**RE: 2900 A&B Corona NW
Grading and Drainage Plan
Engineer's Stamp Date – 6-6-2016
Hydrology File: H11D070**

Based upon the information provided in your submittal received 6-6-2016, the above referenced Grading and Drainage Plan is approved for Building Permit with the following condition:

ENGINEER'S SEAL  6/6/16 DAVID SOULE P.E. #14522	2900 A&B CORONA DRIVE GRADING AND DRAINAGE PLAN	DRAWN BY WCVJ DATE 6-05-16 21625-LAYOUT-6-05-16
	 1606 CENTRAL AVENUE SE SUITE 201 ALBUQUERQUE, NM 87106 (505) 872-0899	SHEET # JOB # 21625

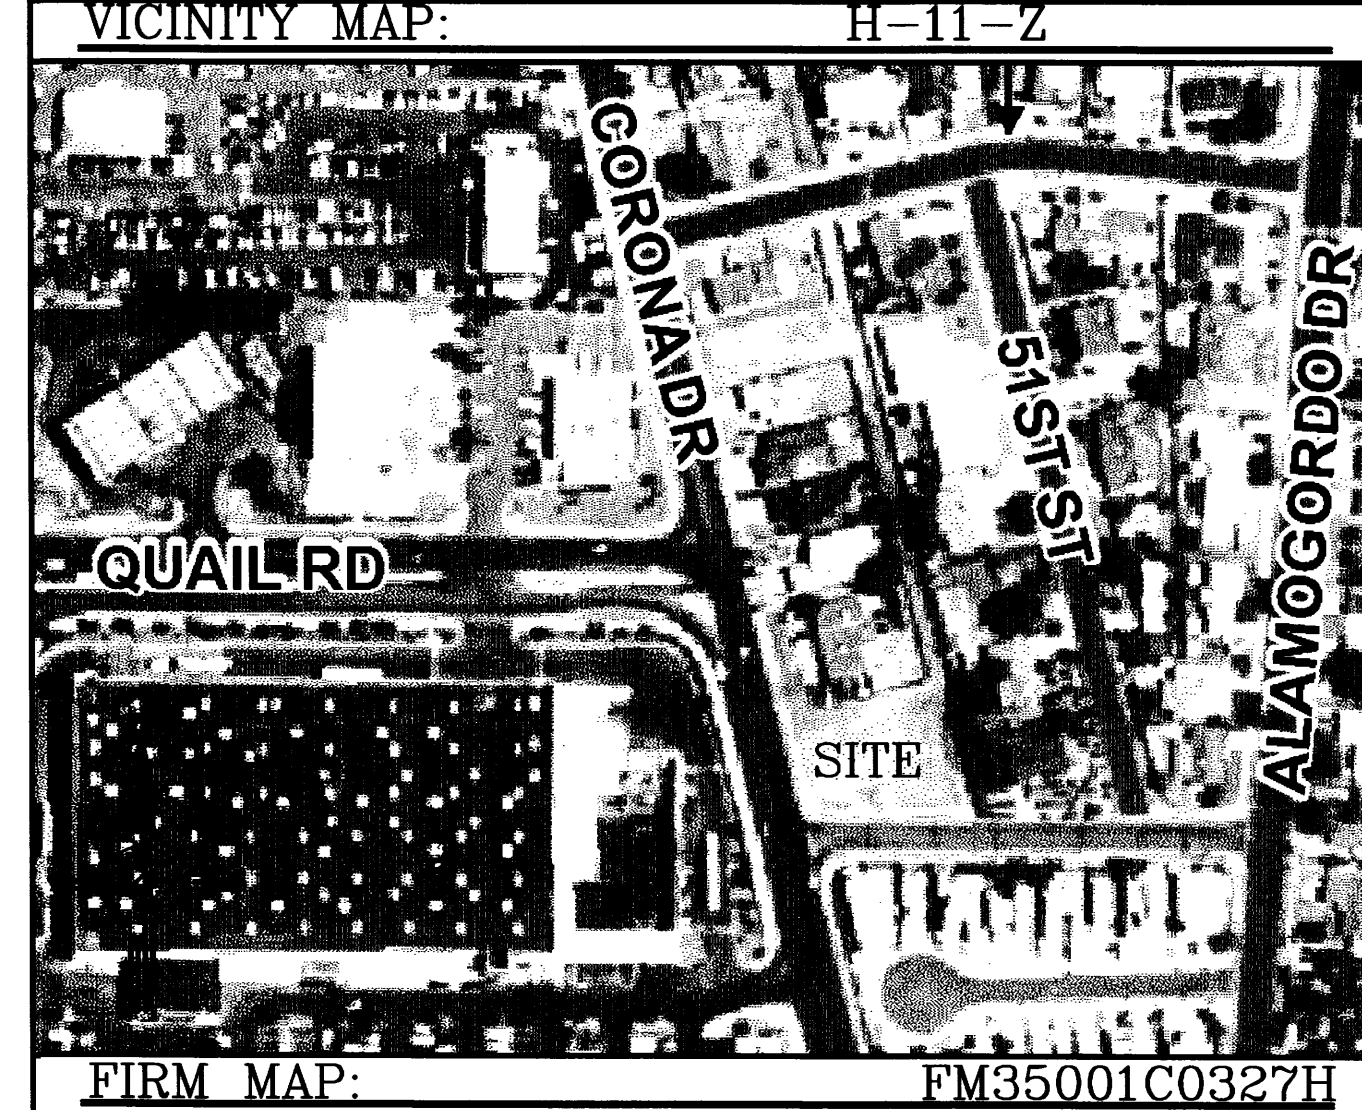
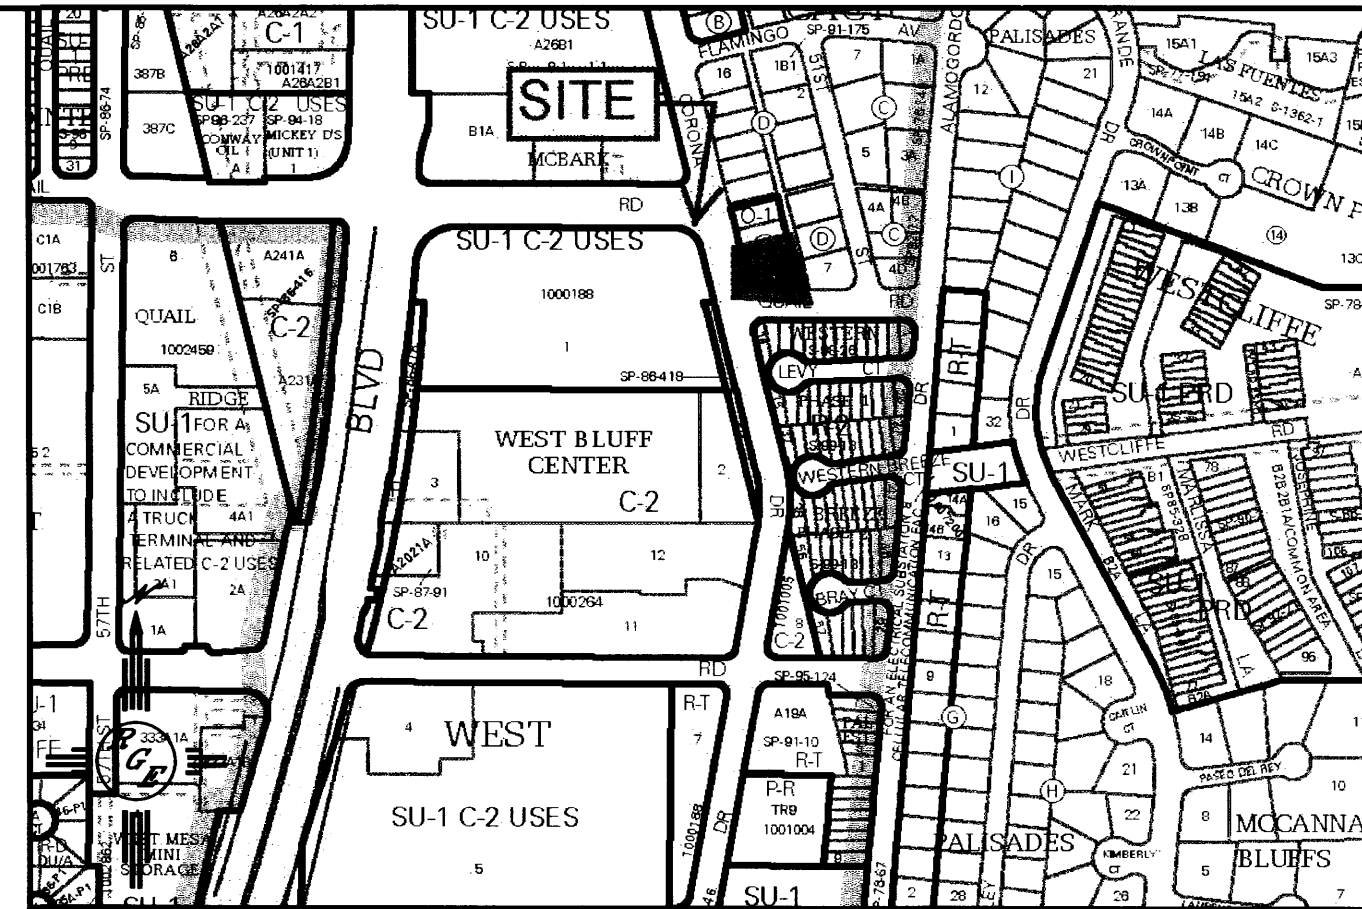
- The location of roof drains is not shown, but it appears that they will be directed North and South. Ensure that roof flows are routed through the first flush ponds.
